Subject: RE: Planning Consultation on: P/146/21/DOC

Engineers Comments Regarding Surface Water Drainage

Application No: P/146/21/DOC

Registered: 18th October 2021
Site Address: Little Sefter Farm Pagham Road Pagham
Description of Works: Approval of details reserved by condition imposed under P/38/21/PL relating to conditions 2-surface water drainage scheme, 4-Landscape & Ecology Maintenance Plan & 5-landscape scheme.

PROJECT	BARN EXTENSION BARFOOTS - LITTLE SEFTER PAGHAM RD, BOGNOR REGIS W SUSSEX, PO20 1LN			
	PROPOSED SW DRAINAGE LAYOUT			
DRAWING	FC2846/02			
	REV C			
SCALE	1:125			
	DATE	JAN 20	MH	CHKD -

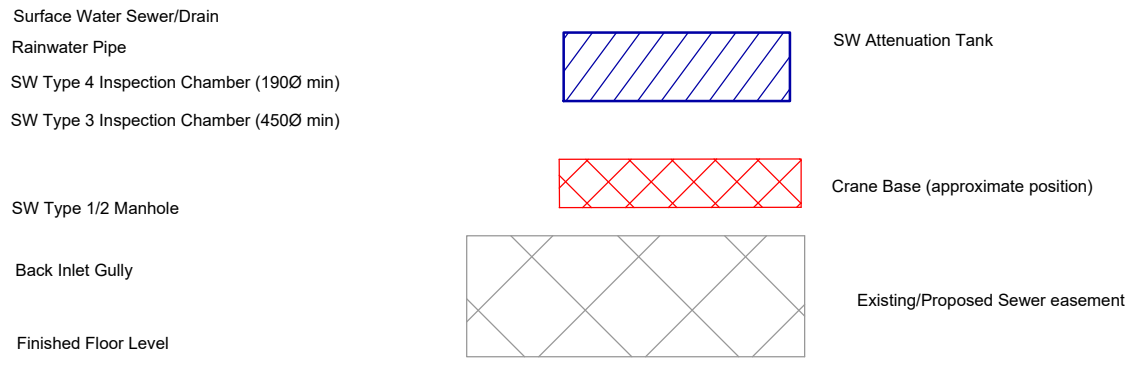
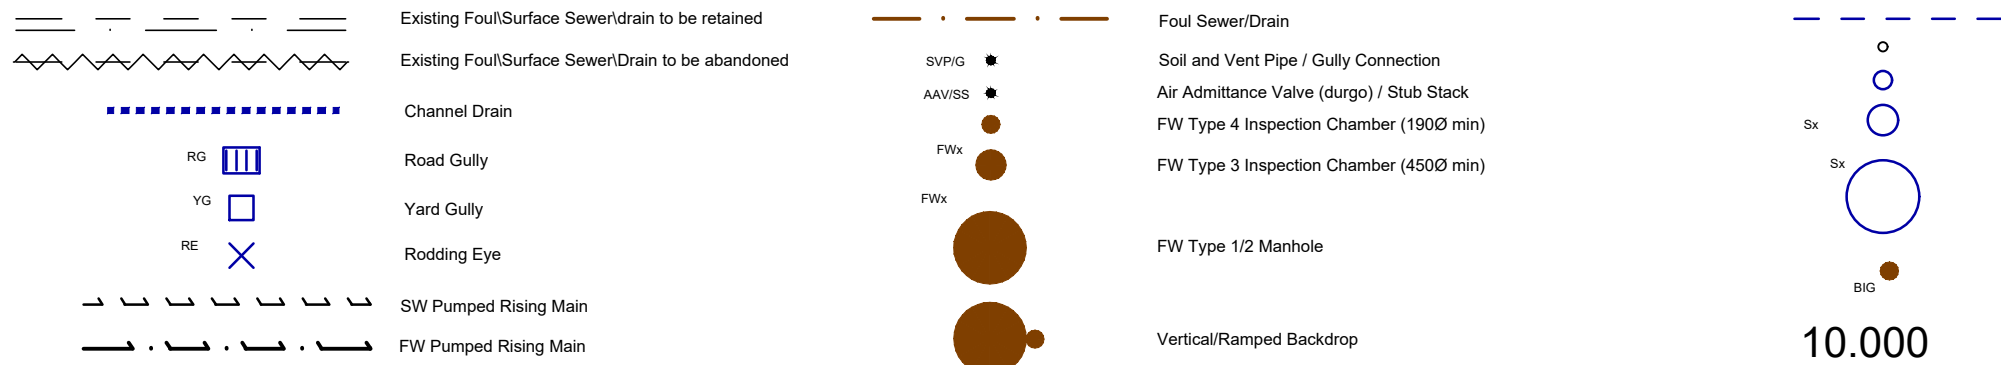
1. Groundwater seepages are noted below 2mbgl in February, please provide any further groundwater monitoring that is available as seepage will not represent standing groundwater level.
2. On the Drainage Layout there is a 'Note the following' The second note relating to the Hydrobrake needs to be adjusted for the new Hydrobrake limiting flow to 2l/s.

3. Please add a note that all pipe junctions (not connected via manholes) need to utilise oblique junctions.
4. Please include the width of the base and the width of the top of the pond (in the absence of a site specific cross sectional drawing or a setting out drawing) on the drainage layout.

SHE-0076-2000-0400-2000
 Hydro-Brake® Optimum

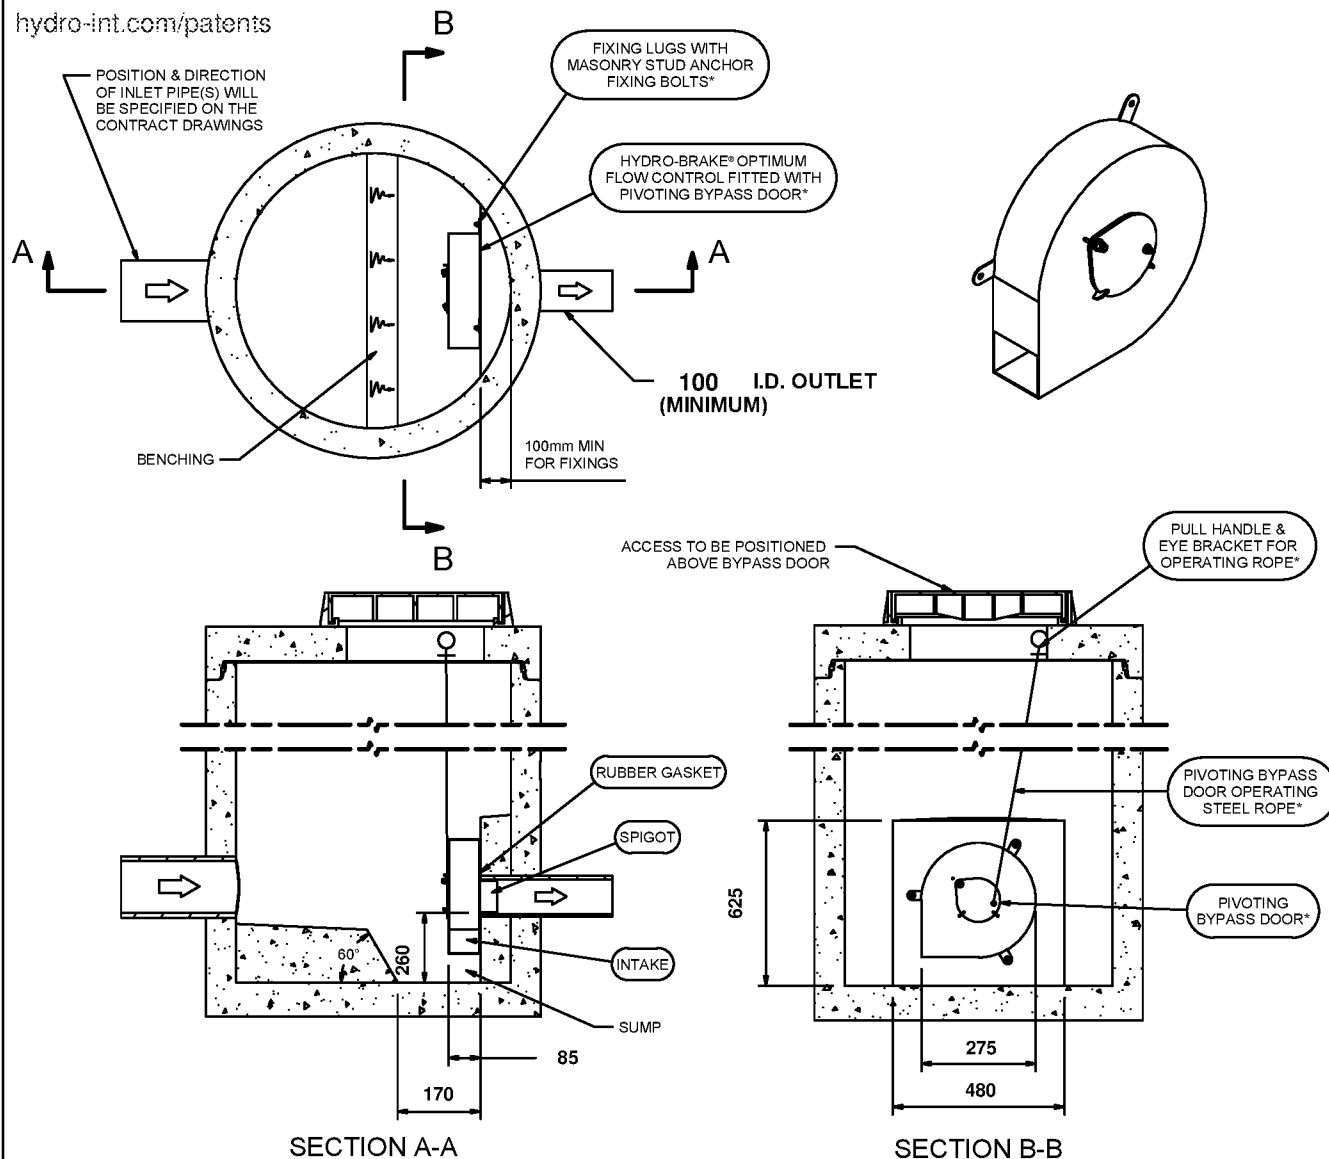
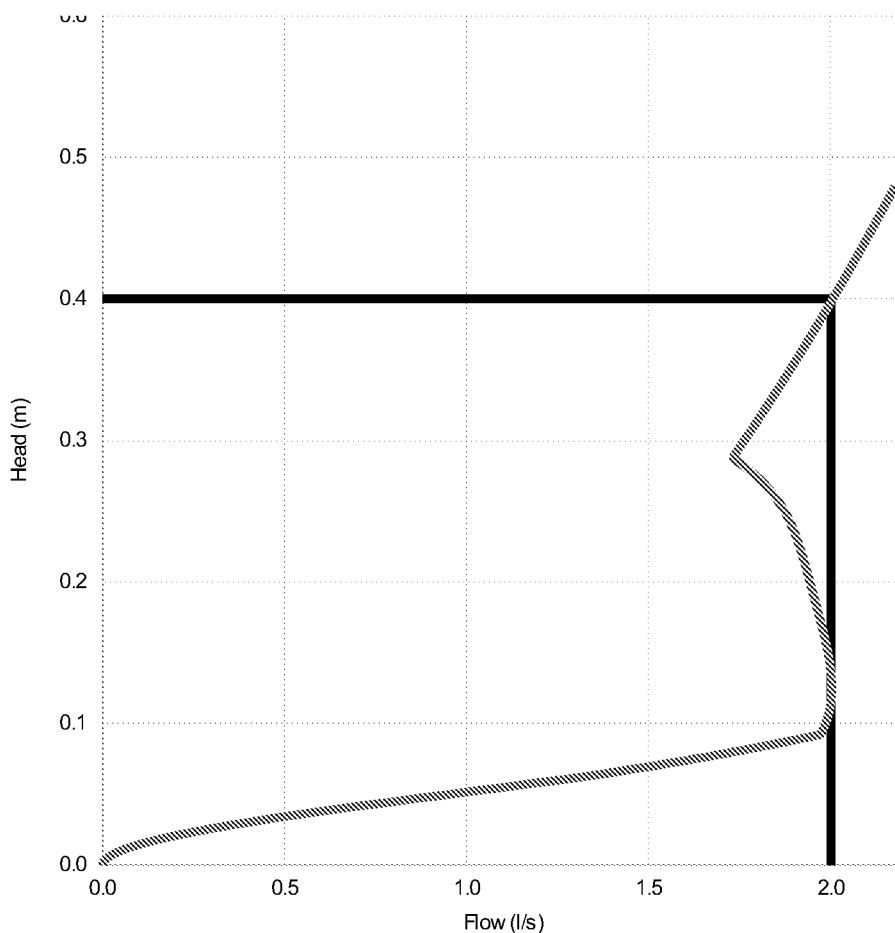
5. Dependant upon the response to point 1 further detail may be required regarding the membrane for the pond (permeable/impermeable) and possible floatation mitigation.
6. Please provide the Althon Detail and Spec for the PCC Headwall Pond Outlet to flow control MH.
7. Please provide a site specific Hydrobrake detail. Please reference the Hydrobrake on the detail drawing and include the following:
 - a) Invert level and cover level.
 - b) Incoming and outgoing pipe diameters.
 - c) No dimensions should be 'tbc' – please clarify.
